Proposed Abercrombie Precinct Redevelopment - Response to Comments from Planning NSW

Arup has been commissioned by The University of Sydney to provide comment on the response to the Preferred Project Report from the Department of Planning & Infrastructure NSW on 14 June 2012 for the application for the proposed Abercrombie Precinct Redevelopment.

Drawing title
PLAN - GROUND FLOOR

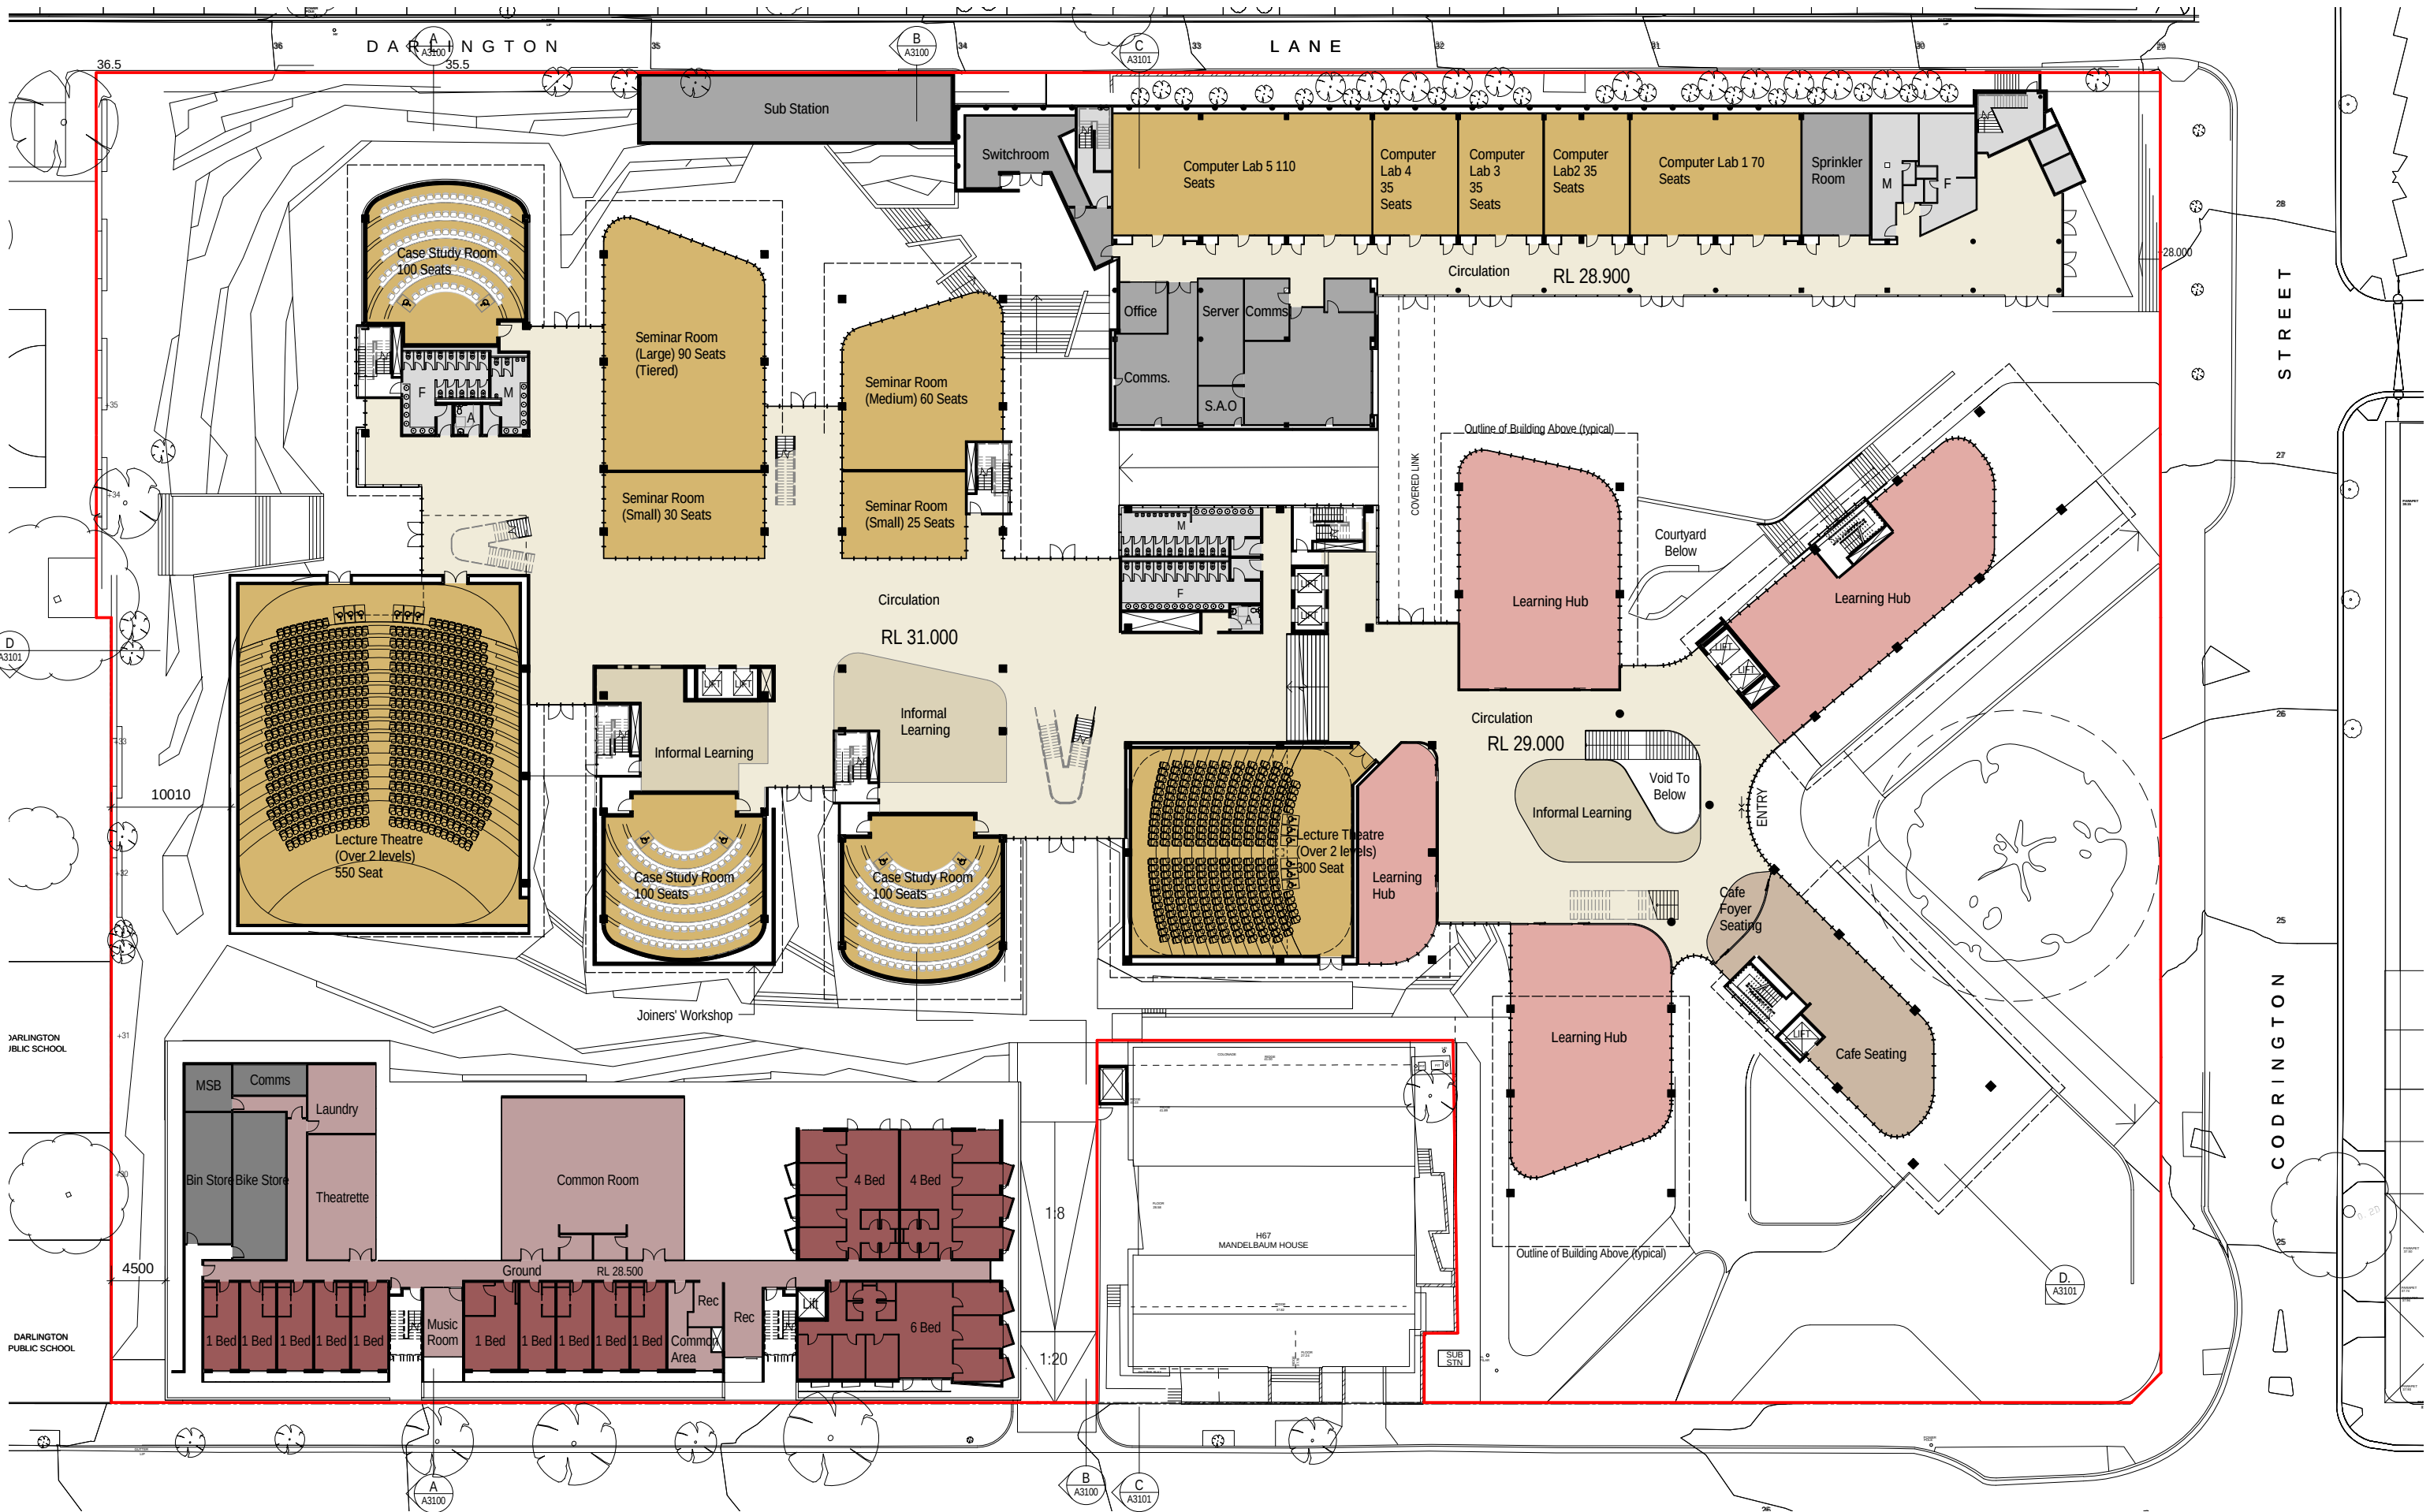
“Significant safety concerns from local residents and public school community have been raised in relation to the proposed location of the vehicular basement access on Abercrombie Street, preferring the car park access be relocated to Codrington Street or Darlington Lane. Further design opportunities should be explored to ensure pedestrian safety is maintained.”

As outlined in the discussion on the background assessment, careful consideration was given to the location of the vehicle access. The provision of the vehicle access on Abercrombie Street is considered to be the most appropriate, given its distance to all other intersections and the allowance for pedestrian focus through and around the site.

As with any access, the increase in potential conflicts leads to an increase in risk. The following measures were considered in the design of the intersection in order to manage the risk at the access between pedestrians and vehicles:

- The use of a boom gate was considered to manage vehicles entering and exiting the development. Concerns were raised that drivers would be more likely to perceive right of way once the boom gate was lifted, thereby reducing the focus on potentially crossing pedestrians. As a result, it is proposed not to manage the access with a vehicle boom gate

- Appropriate pedestrian visibility splays will be provided to ensure that the vehicles exiting the development will have adequate sightlines for oncoming pedestrians

- Appropriate “GIVE WAY TO PEDESTRIANS” signage will be provided on egress to the development indicating that pedestrians on the footpath have right of way

- A shallow grade for egress of 1 in 8 will be provided encouraging slow egress from the development as steeper slopes tend to encourage acceleration
- A variable message board will be provided indicating the number of vehicle spaces available within the car park to prevent vehicles entering and exiting the development unnecessarily

- A driveway footpath will be provided at the access indicating to vehicles that the pedestrians on the footpath have right of way as with other vehicle accesses which are located in the area such as Maundelbaum House and

- The driveway footpath will be discoloured from the standard footpath highlighting the change to more vulnerable pedestrians, a feature used at the adjacent Maundelbaum House.
